**Consultation Response from KC,  
Lead Local Flood Authority**
**2020/90441 Pennine Service Station, Bradley Road, Bradley, Huddersfield, HD2 1QD**
**Discharge conditions 3, 6, 7, 18 on previous permission 2019/92233 for erection of petrol filling station, including new shop building, canopy, jet-wash and below ground storage tanks**
**Date Responded: 6  
August 2020**
**Responding Officer:  
Aleksandra Tomczyk**
**Responding Ref: 03**

**Summary**

Kirklees LLFA **OBJECT** to discharge of conditions 3 and 7 and require **FURTHER INFORMATION** to be provided on the design of surface water discharge system. Kirklees LLFA have no objection in principle, to discharge of condition 18. However, this condition cannot be recommended to be discharged before conditions 3 and 7 are fulfilled as well.

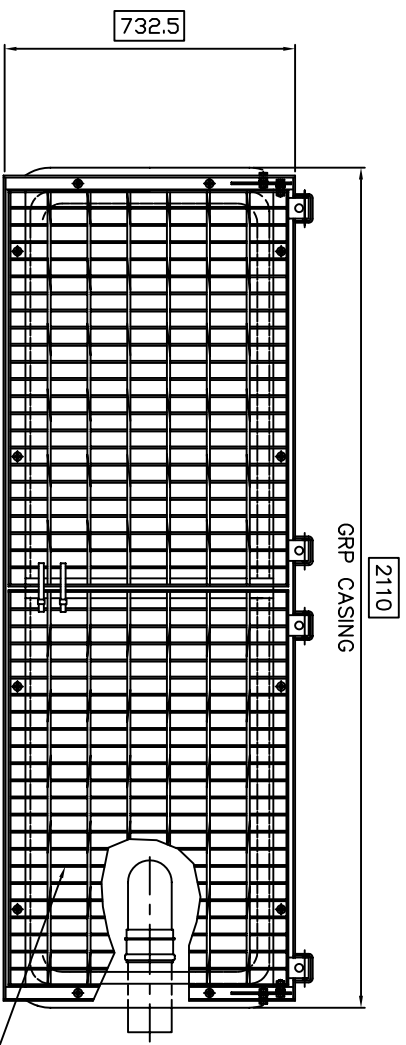
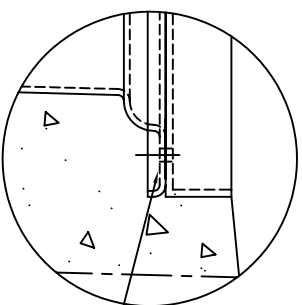
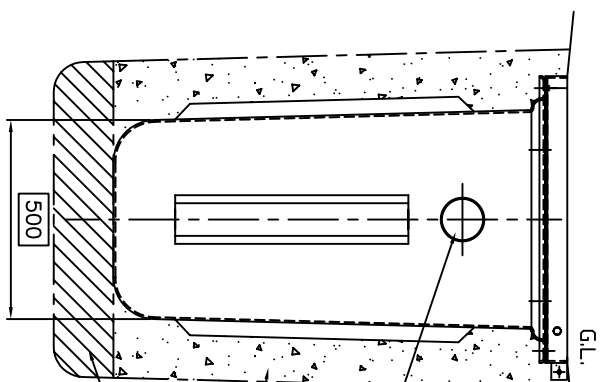
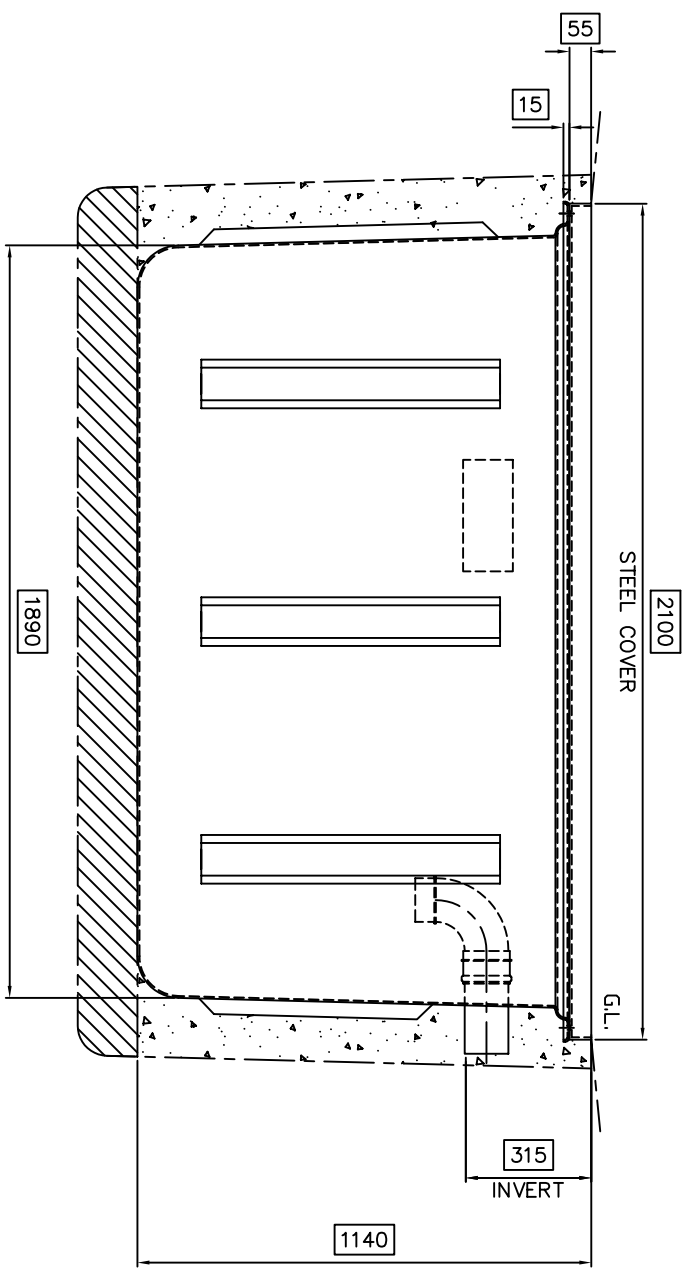
- Kirklees LLFA have **no objection in principle** to the proposed sizing of the attenuation tank – 31.92m<sup>2</sup> (including the 95% void ratio).
- Reviewing the *Drainage Details* drawing in more detail, it appears that the cover level for the proposed crate storage tank is insufficient for this type of development. Based on manufacturer guidance for such systems, the cover level should be at minimum 0.8m for locations where cars parked are occasionally over 2500kg in weight. The applicant should review this and provide updated information, the applicant could use a structural slab above this or modify the attenuation design.
- Details of the light duty and heavy duty have been provided as requested. The LLFA have no further comments on this aspect.
